TO: All Staff
FROM: Justin Turnbull, County Surveyor 
DATE: August 8, 2019
SUBJECT: County Survey Review of Final Short Plat SPF-19-0003 (Jerke)

Required Changes

DWN BY	DATE	JOB NO.
G. WEISER	8/2019	17195
CHKD BY	SCALE	SHEET
M.K.K./D.L.P.	1" = 100'	1 OF 3

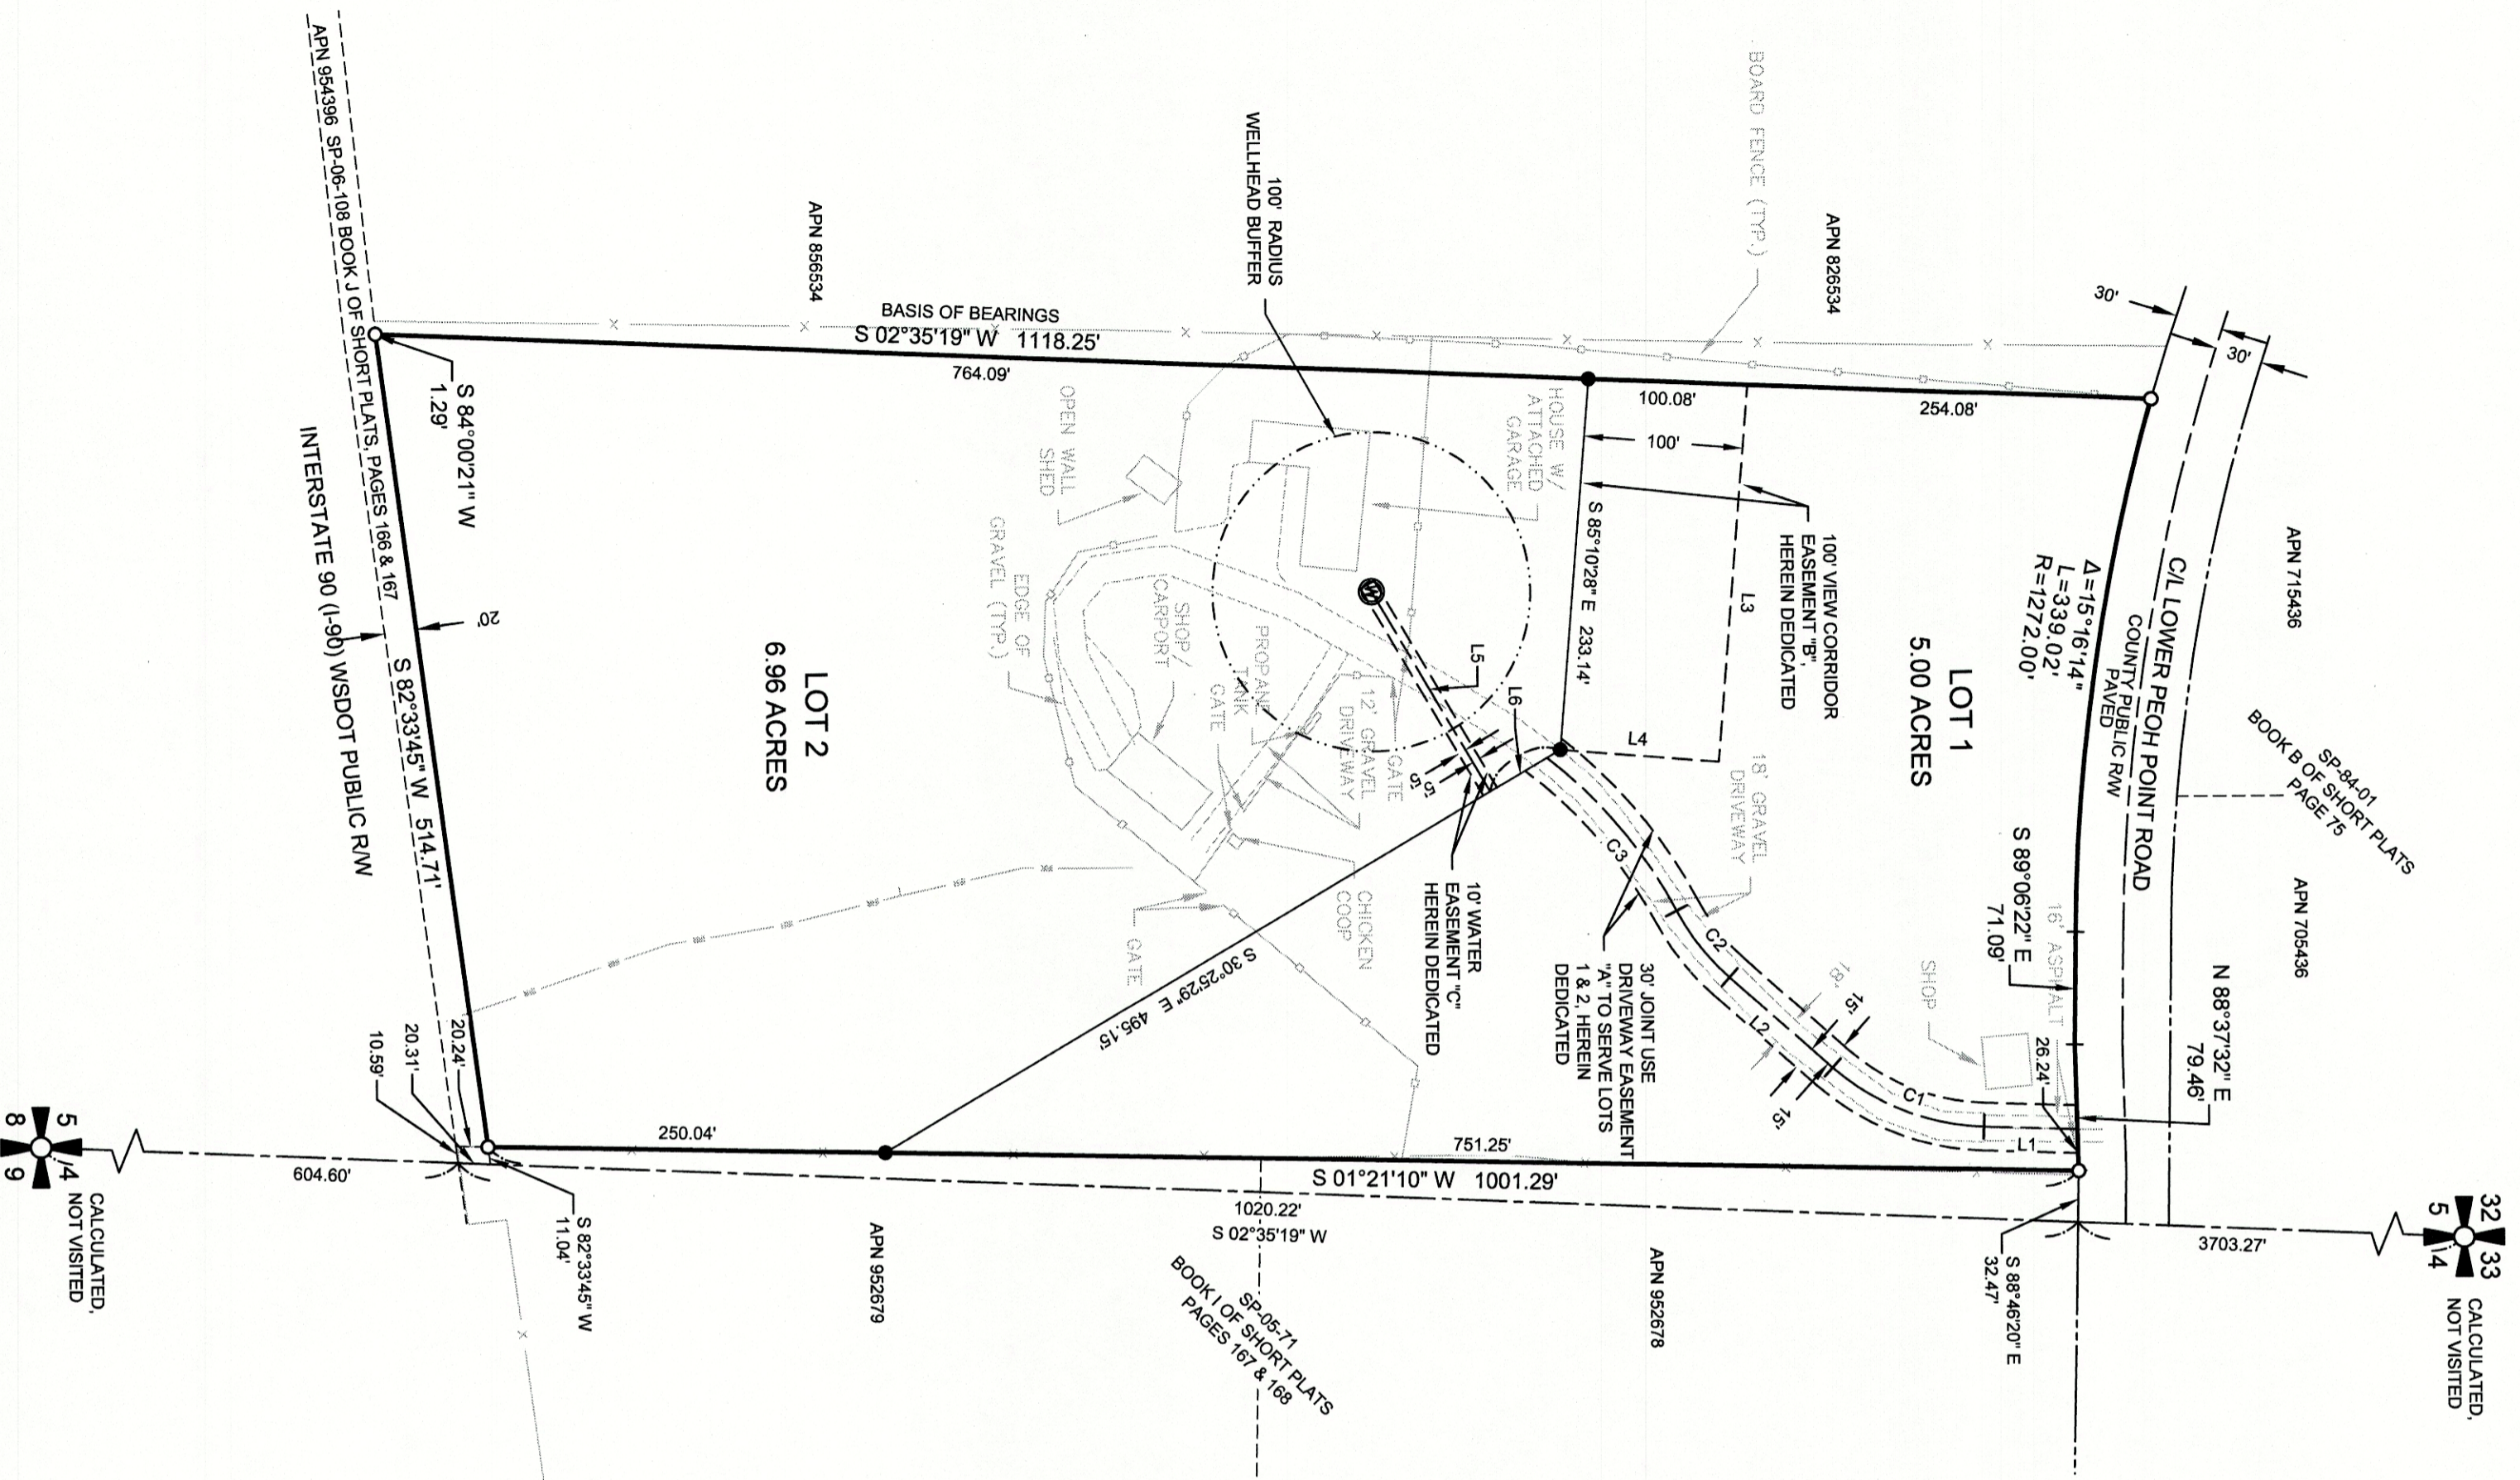
1. Greyscale linework is not allowed.
2. Basis of Bearing on map does not match survey notes on sheet 2.
